## KITTITAS COUNTY COMMUNITY DEVELOPMENT SERVICES

**Subject: Suncadia Phase 2 Division 6 (LPF-21-00005) Final Long Plat – Staff Review, Return of Application- Additional Information Required.**

NELSON RIDGE SUNCADIA - PHASE 2 DIVISION 6

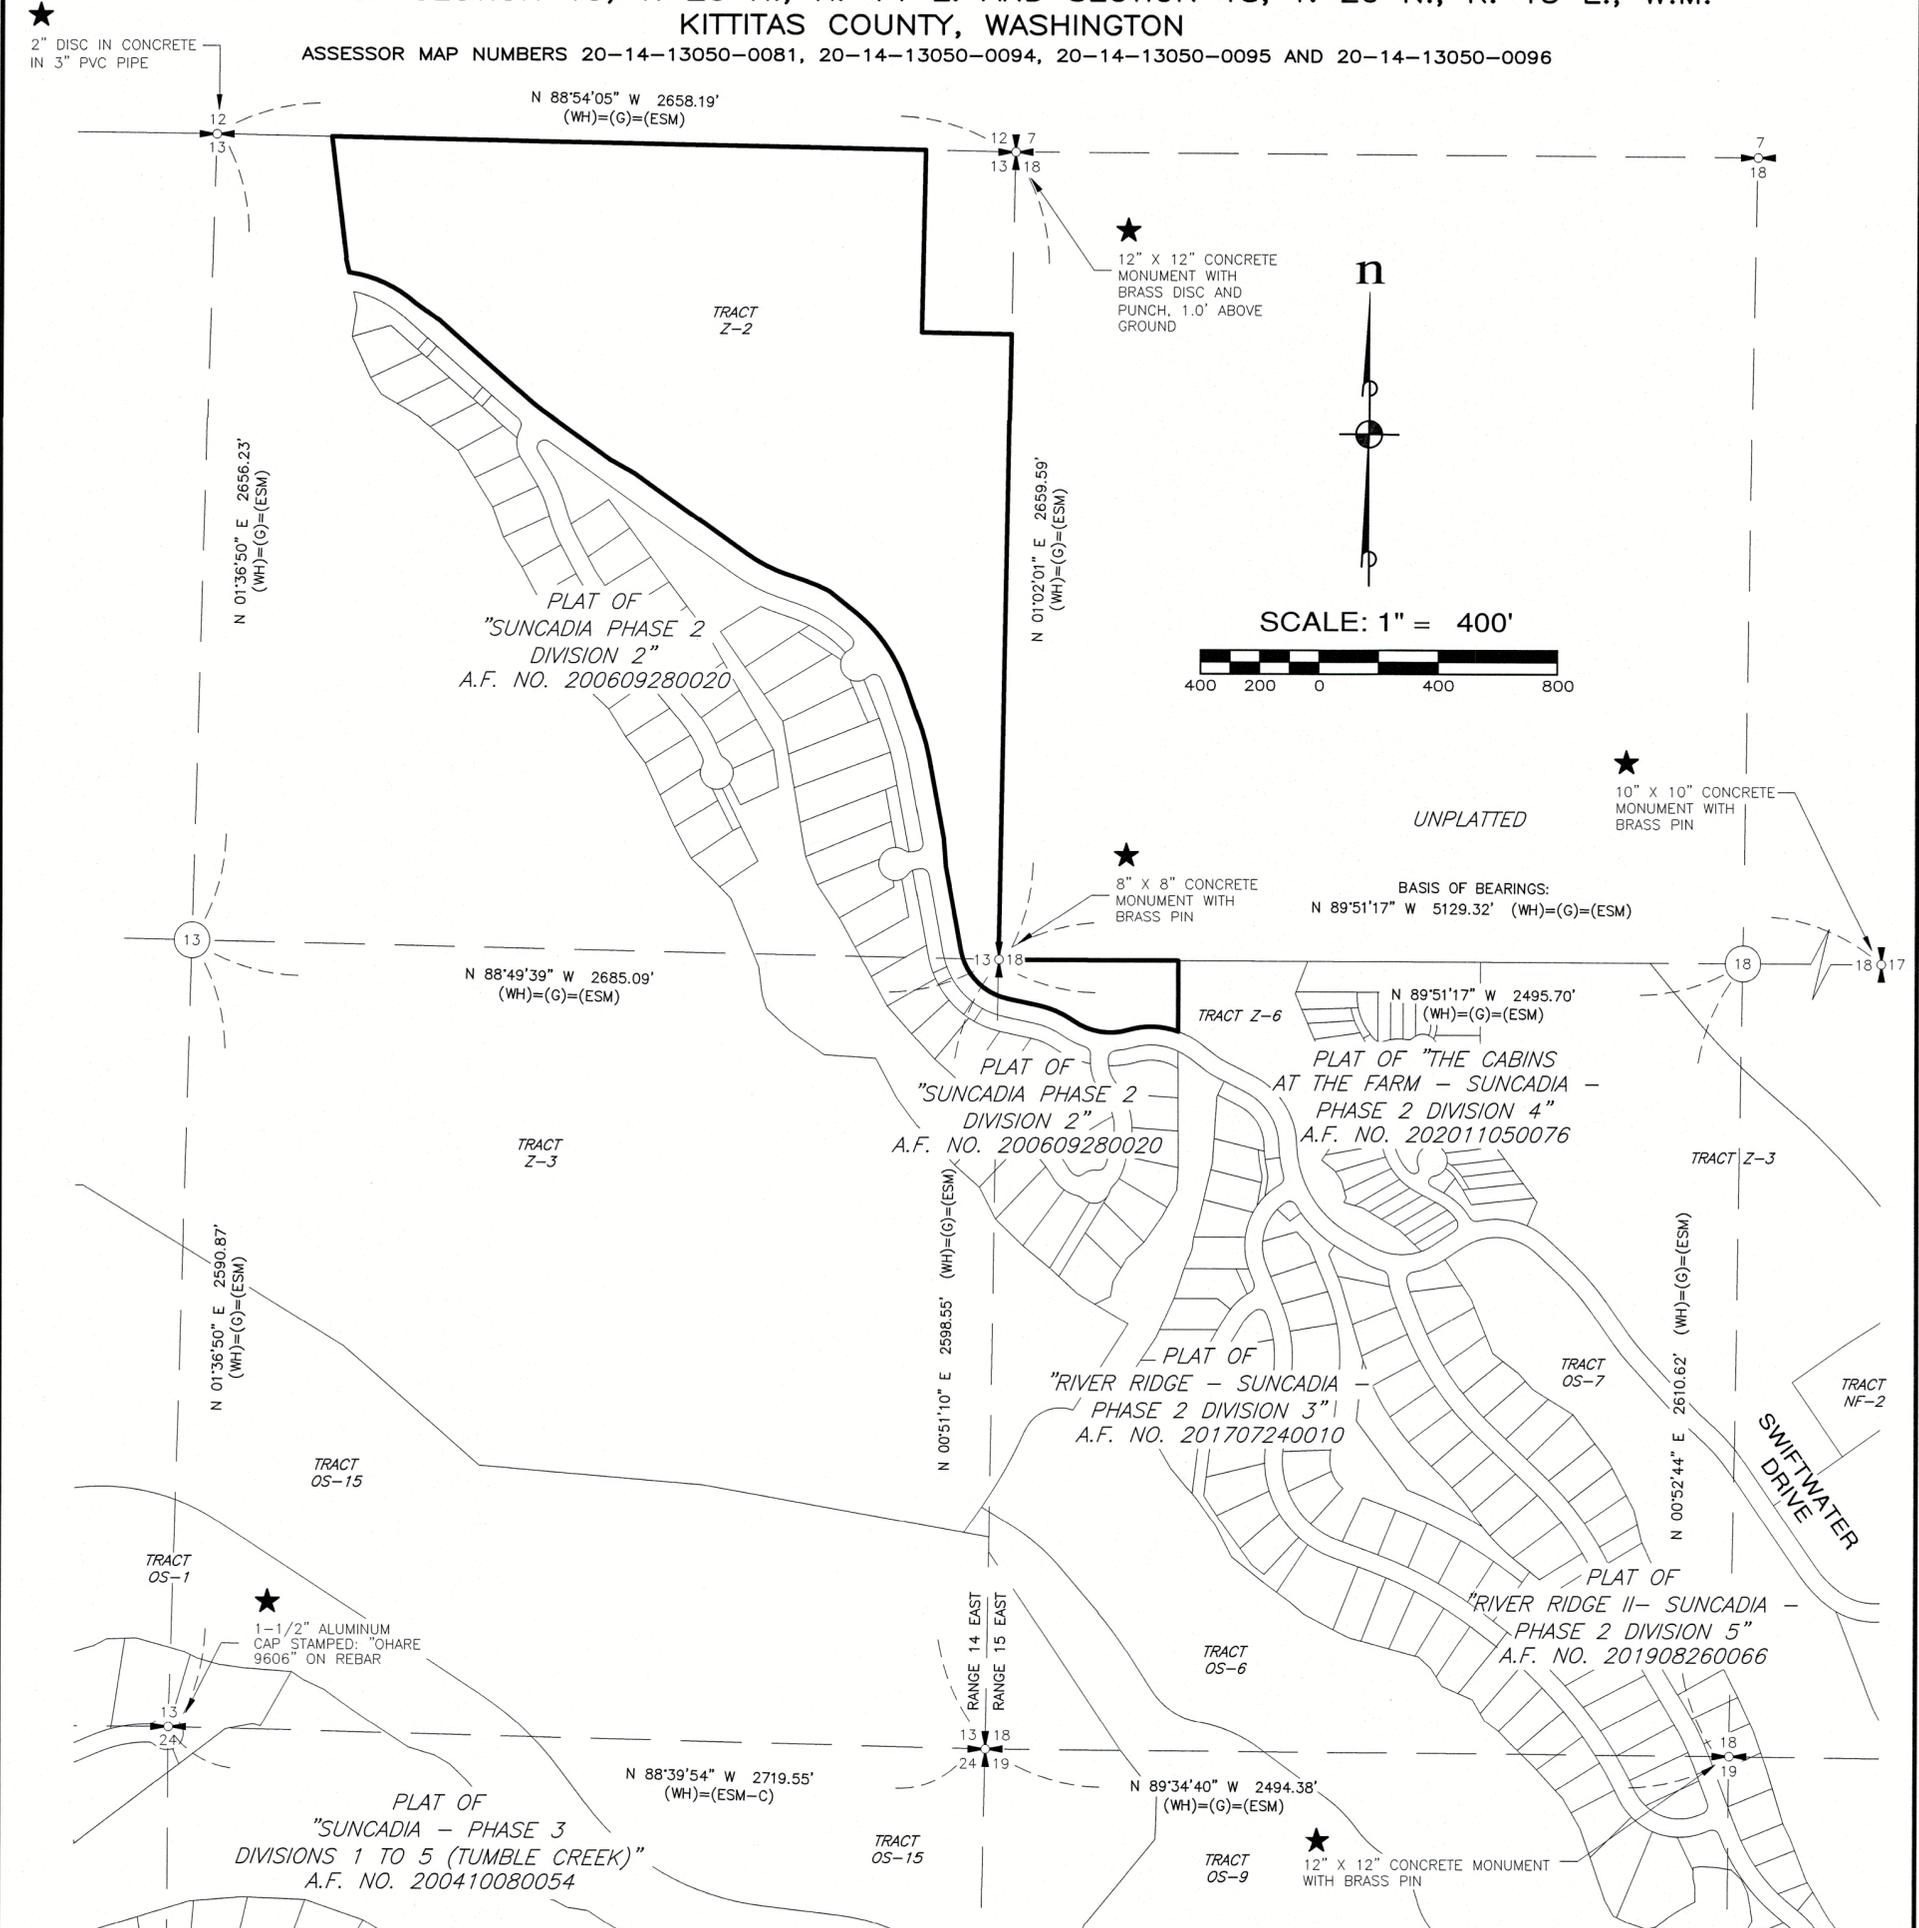
- The final mylars shall note the final plat file number LPF-21-00005 on the face of the plat in addition to the preliminary approval number already noted.
- Taxes on parcel #'s 951841, 951854, 951855 and 951856 must be paid in full before final signature.
